**Consultation Response from KC,  
Highways Development Management****2024/92297 Adjacent to, 71, Woodhead Road, Honley, Holmfirth, HD9 2RJ****Erection of two detached dwellings****Date Responded: 10/10/2024****Responding Officer: Ryan Kinder****Responding Ref: K3-49/50****RECOMMENDATION: No objection subject to conditions.****Development Overview:**

This application seeks approval for the erection of two dwellings adjacent to 71 Woodhead Road, Honley.

- Proposed site plans ref 20/313/03j dated 02/20

scale 1:500
date 02/20
sheet size A2
dwg. no. 20/313/03j

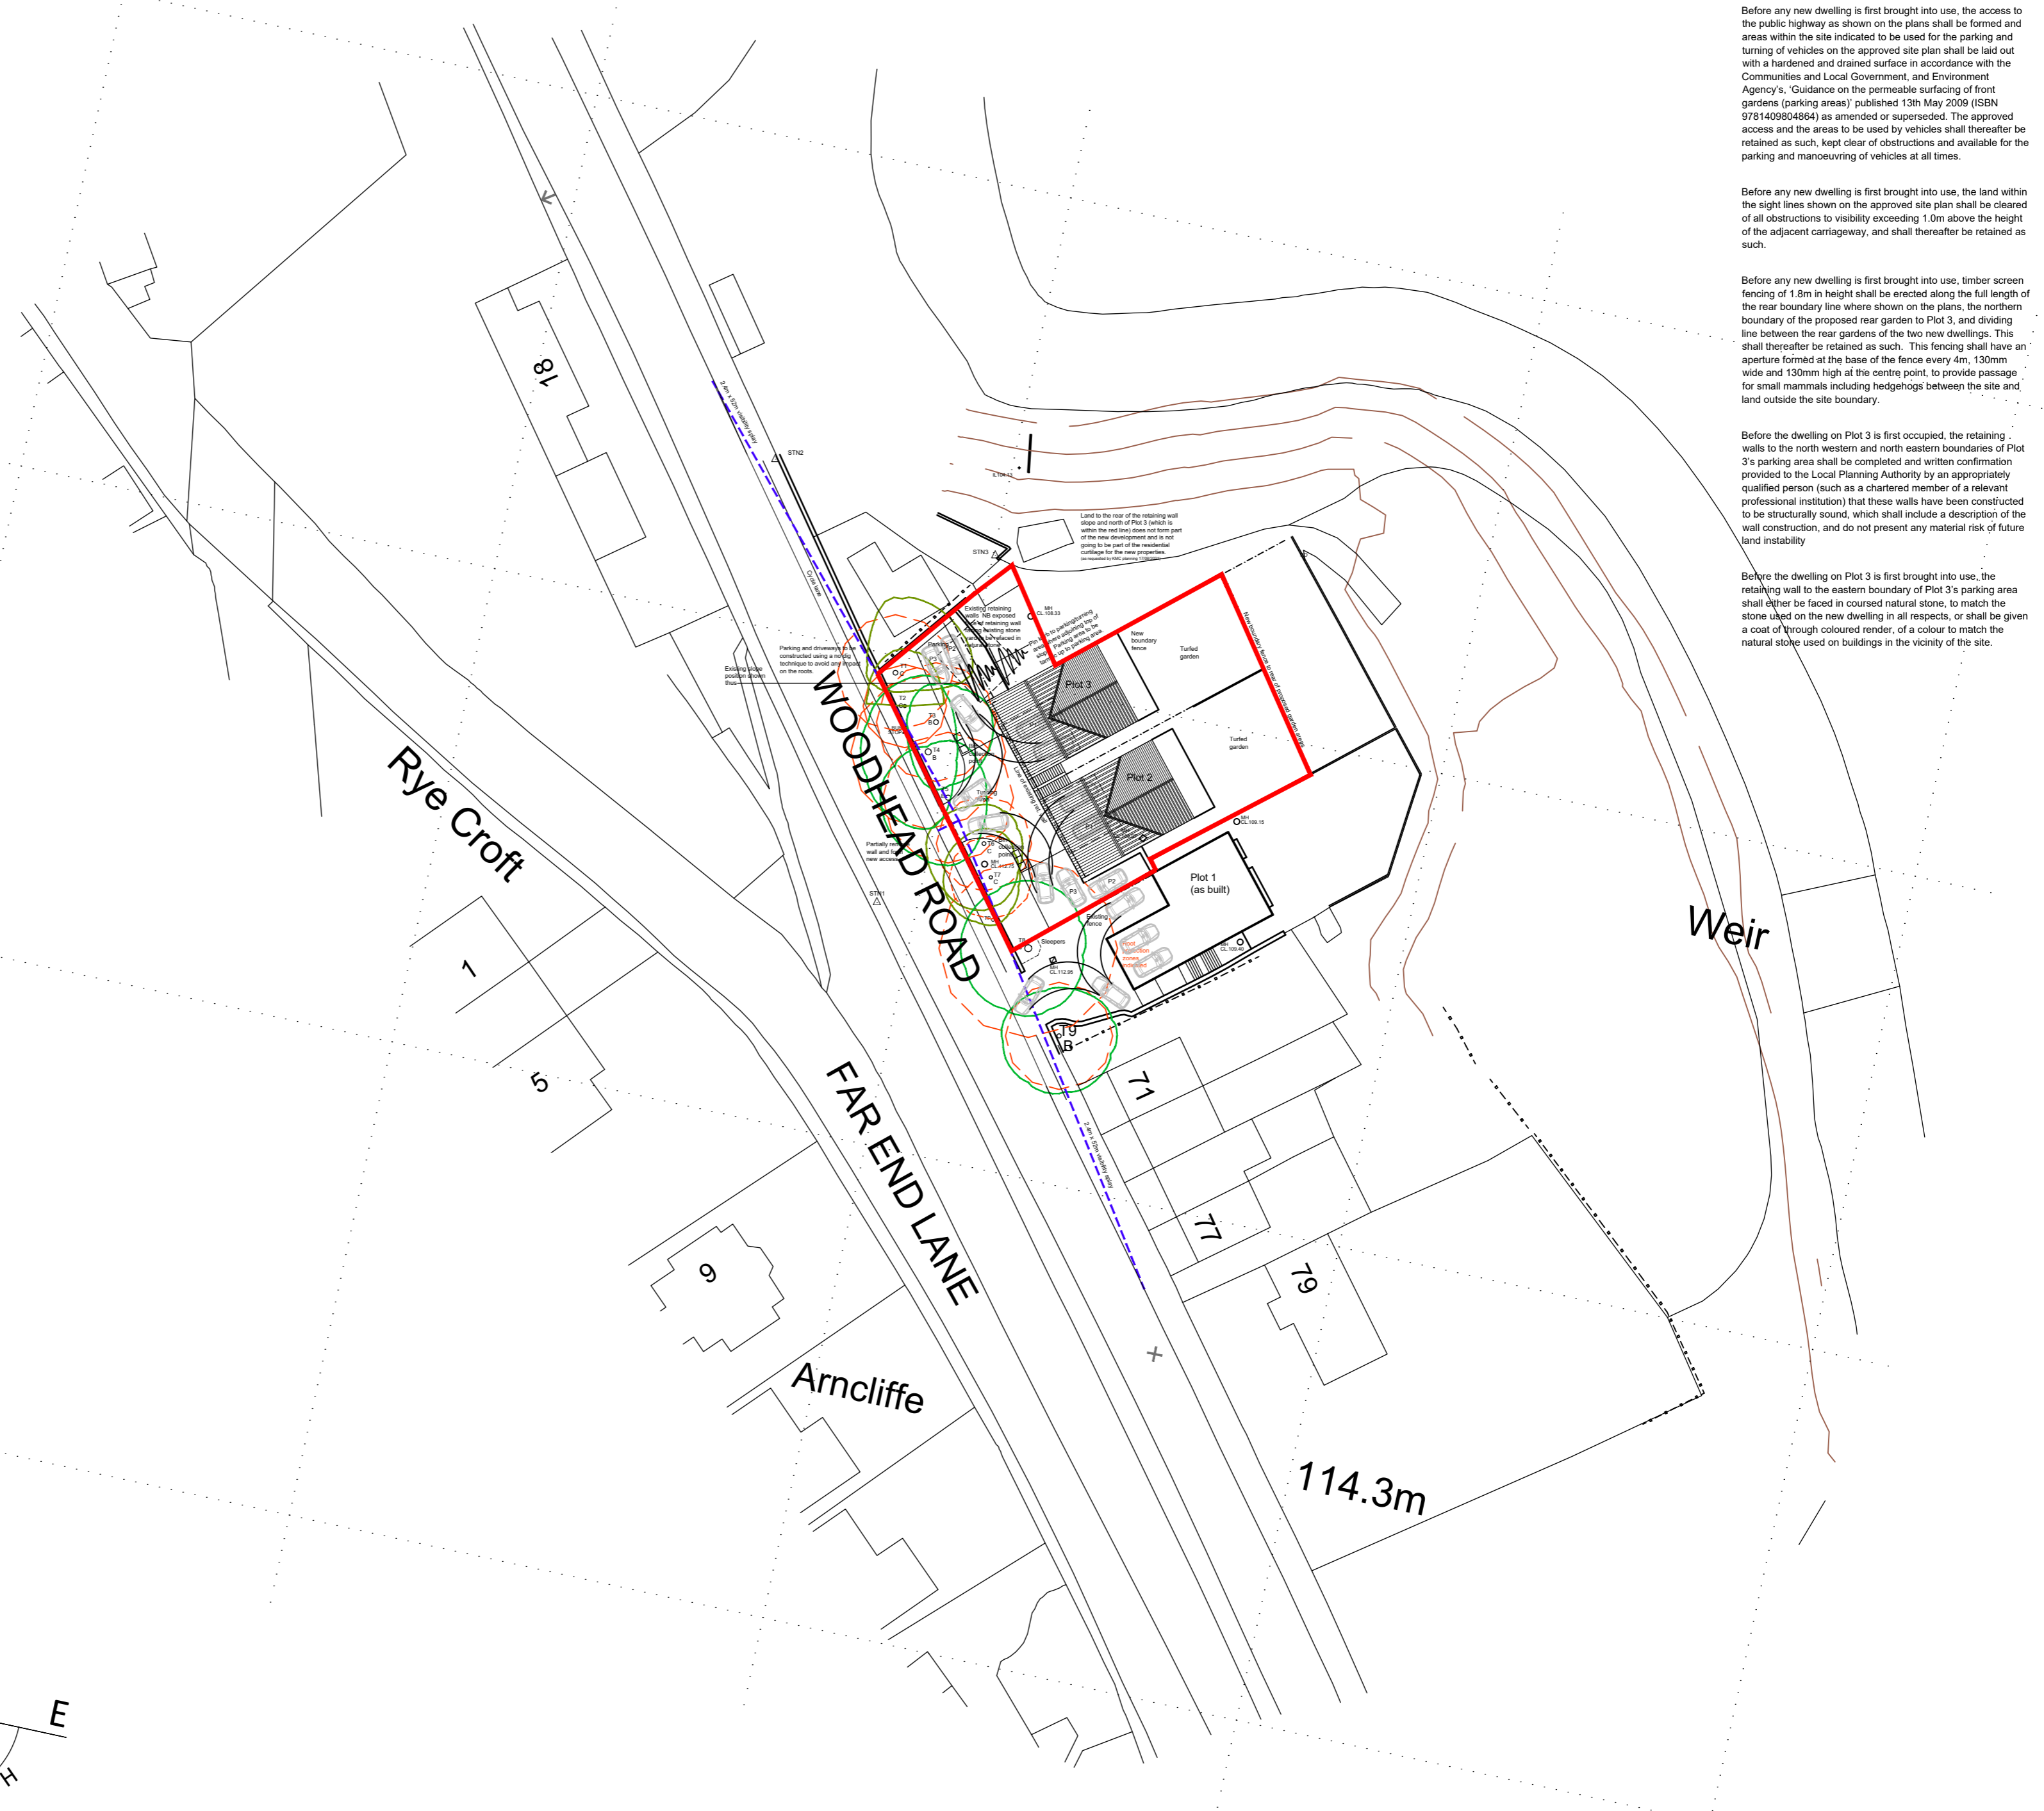
Access to the site is to be taken via a newly formed dropped crossing onto the A6024 Woodhead Road, the submitted information indicates that access is to be formed in between the existing tree line. Suitable sightlines have been demonstrated to this effect and considered acceptable.

The proposed parking provision for 4 spaces per dwelling is considered more than required for a development of this size, with additional space for turning to enter and exit the site in forward gear.

Overall the proposal is considered acceptable from a highways perspective, please include the following conditions:

Unless otherwise agreed in writing, prior to the development being brought into use, the approved vehicle parking areas shall be surfaced and drained in accordance with the Communities and Local Government; and Environment Agencies 'Guidance on the permeable surfacing of front gardens (parking areas)' published 13th May 2009 (ISBN 9781409804864) as amended or superseded; and thereafter retained throughout the lifetime of the development.
